March 13, 2017

Re: Restaurant and Mercantile Fit-Up, 6 City Center

Portland, Maine

Please see the answers below and attachments to address your comments.

A3-0

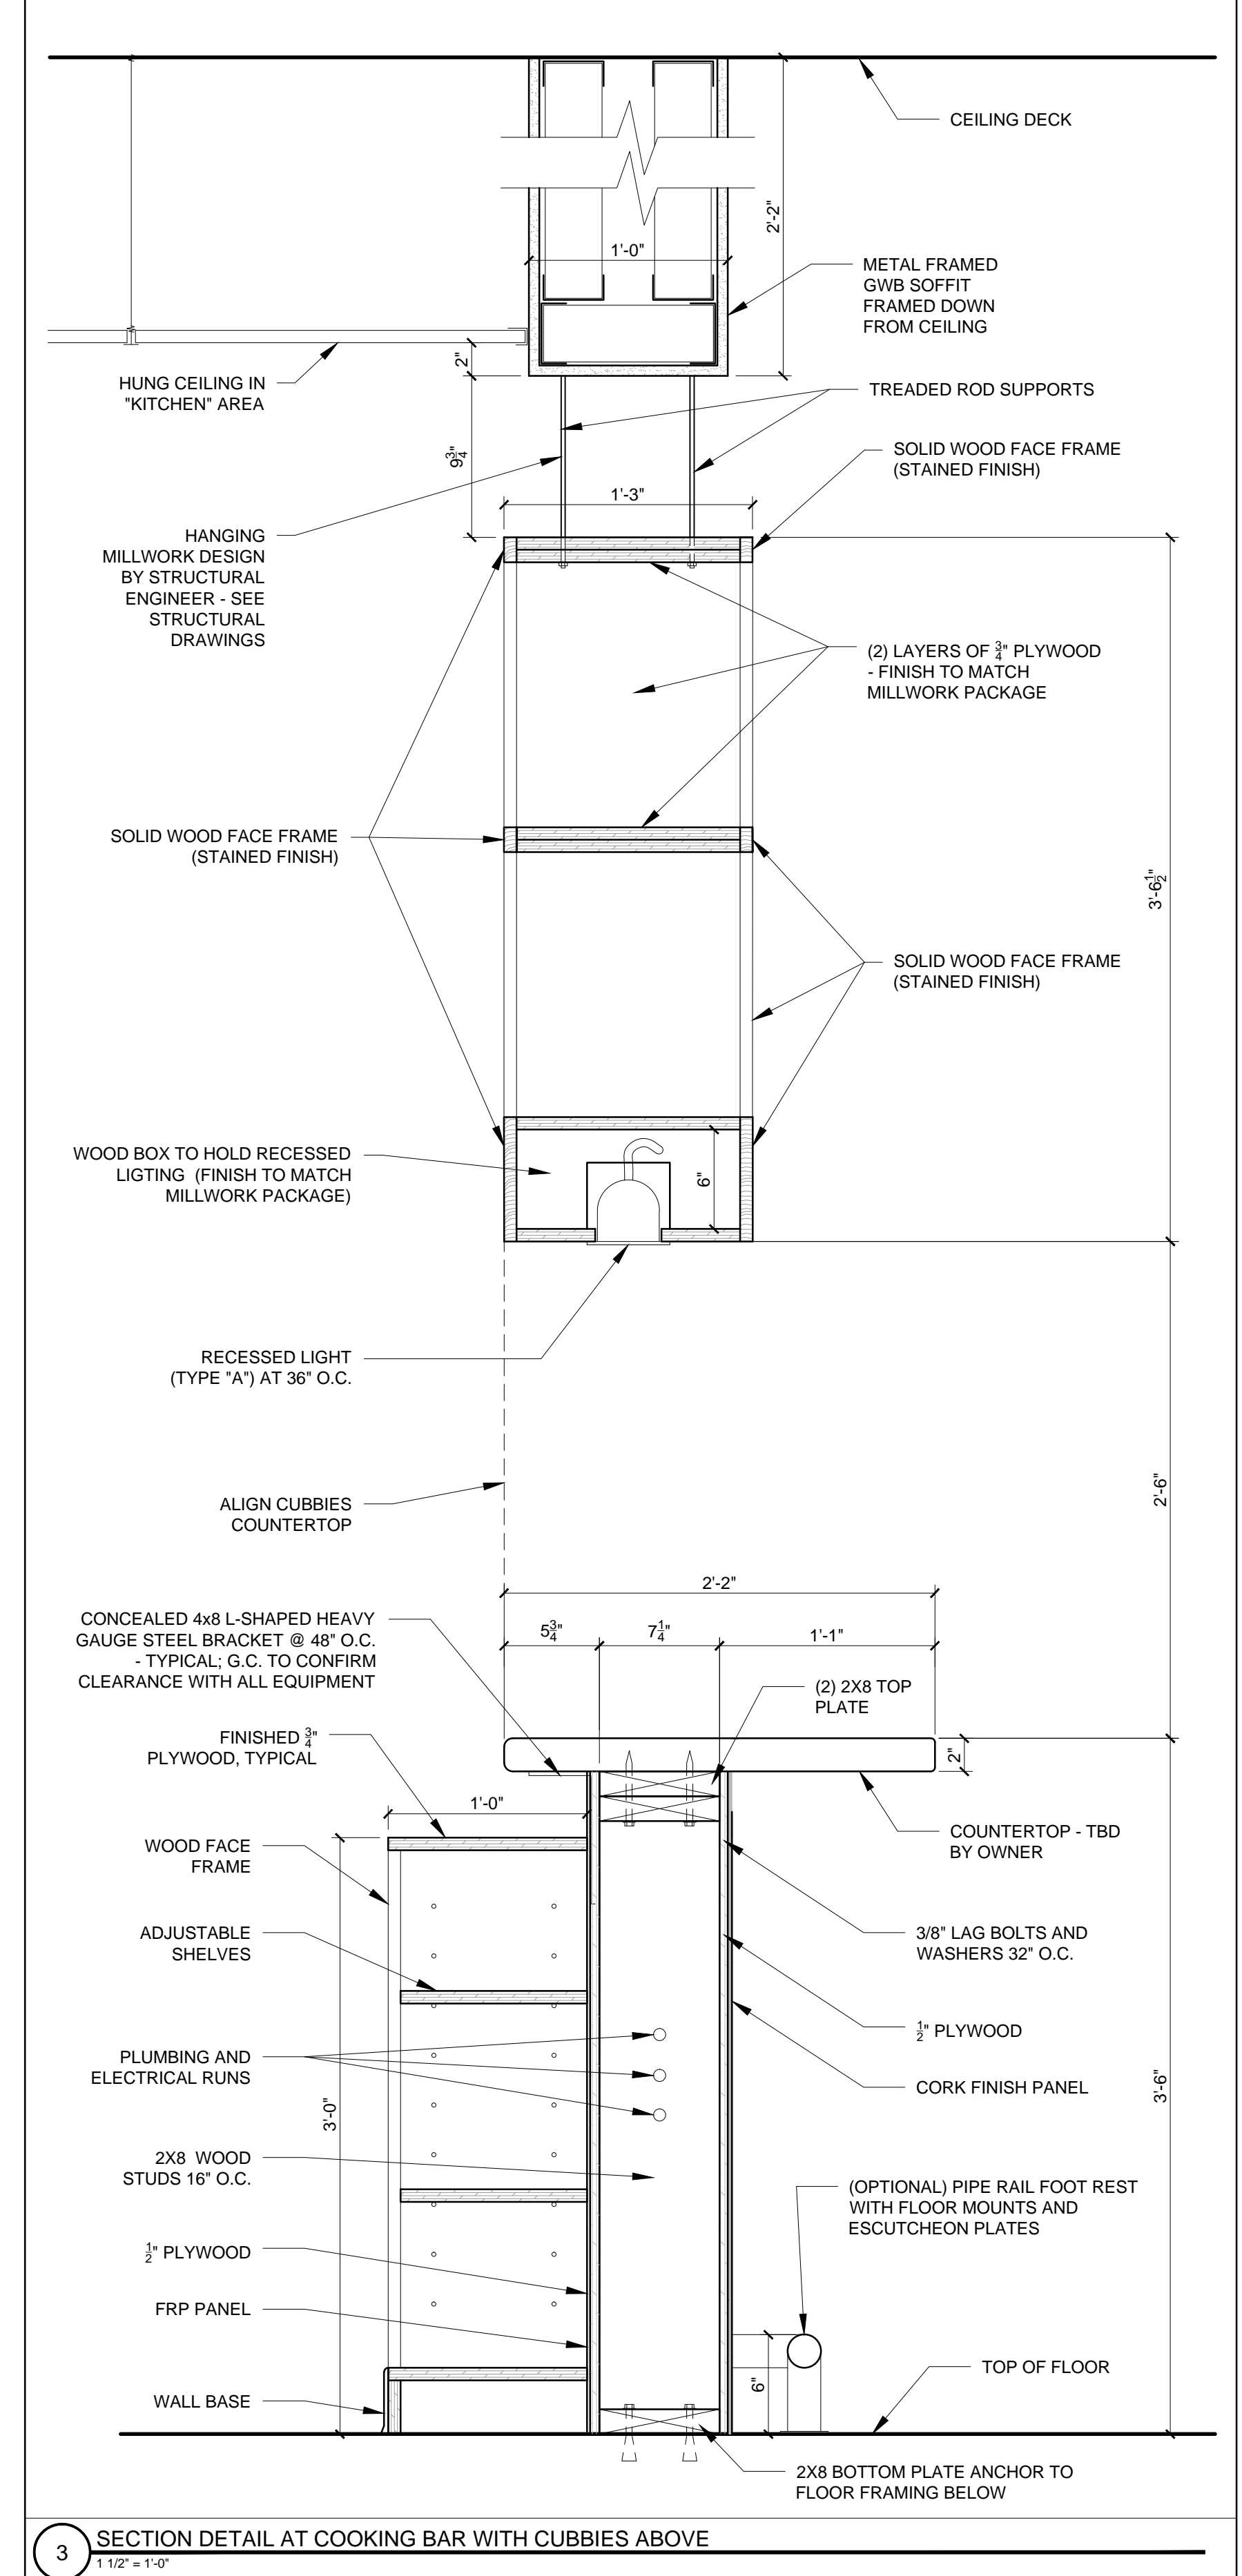
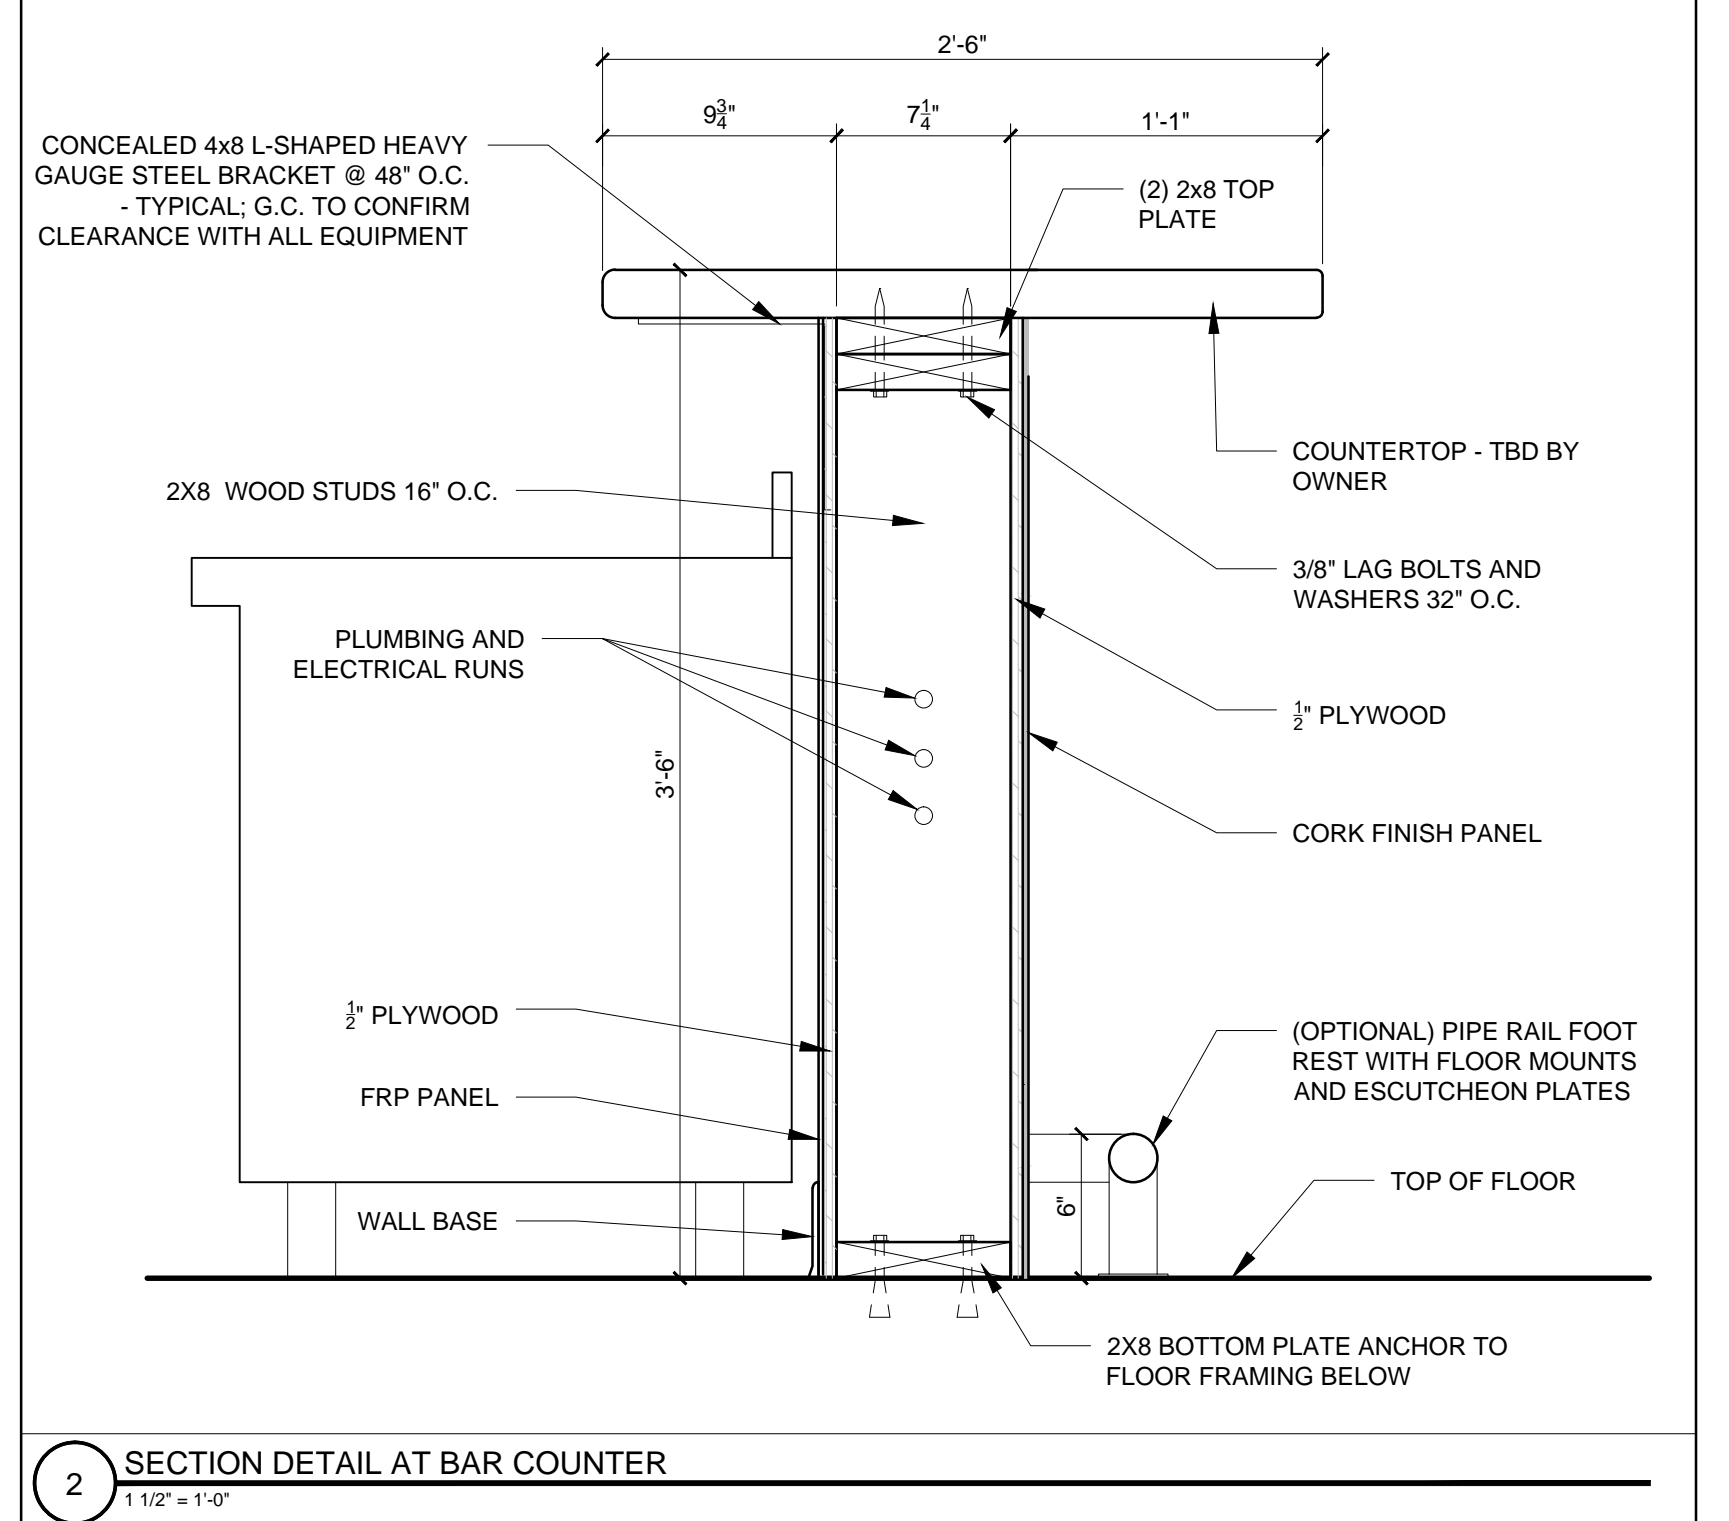
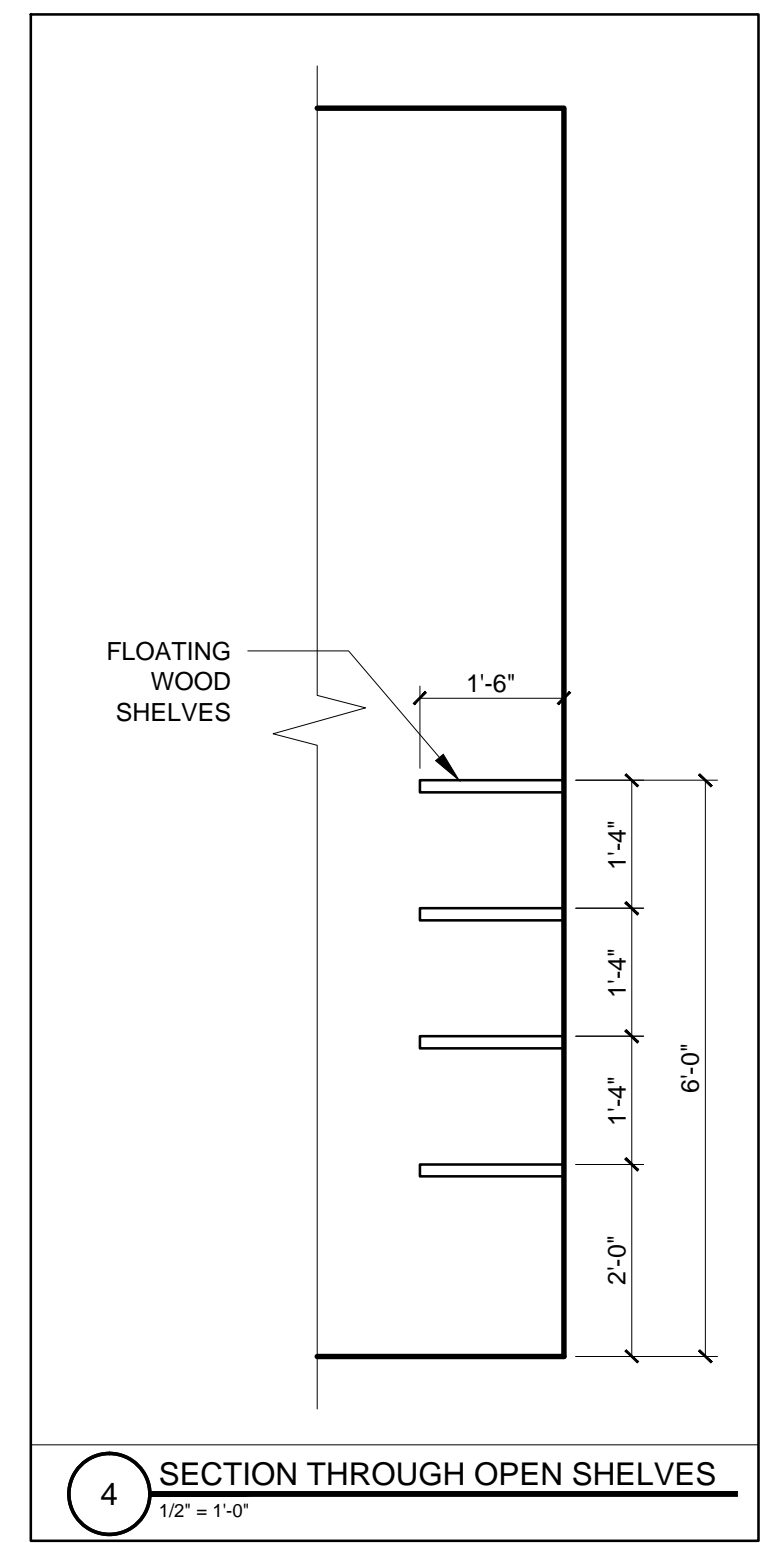
A3-0 There will not be any equipment or storage on top of the bathroom ceiling
